Letter No. A1/15457/2002

Sub: CMDA - Planning permission - Construction of Residential Building at Plot No.9, S.No.437 part of zamin Pallavaram Village (Ground cum Stilt + IFloor ~~(part)~~ + IIFloor (part) with 2 Dwelling Units) Developments charges and other charges to be remitted - Regarding.

ELEVATION

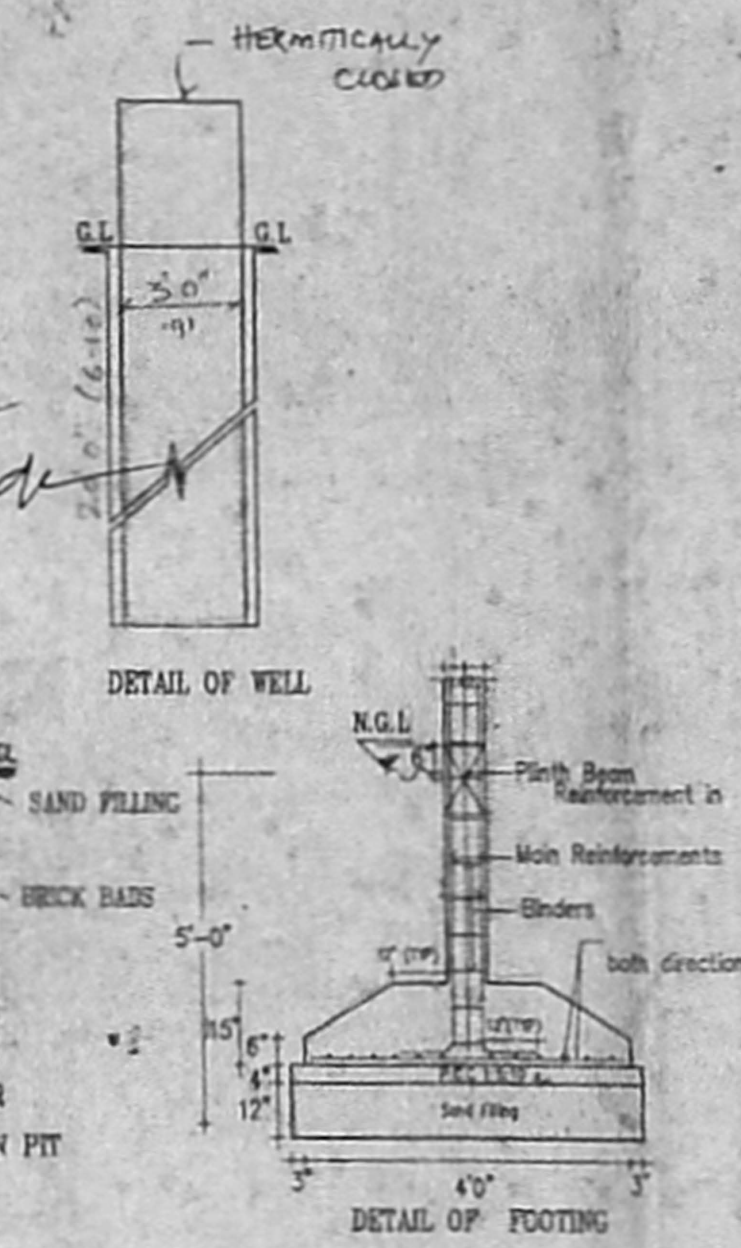
- a) Rain water conservation regulations stipulated by CMDA should be adhered to strictly.
- b) 5 Copies of Revised Plan showing the stilt floor height as 2.2m and the elevation drawn to be drawn to scale.
- c) Copy of sanctioned demolition plan duly attested by Local Body official.
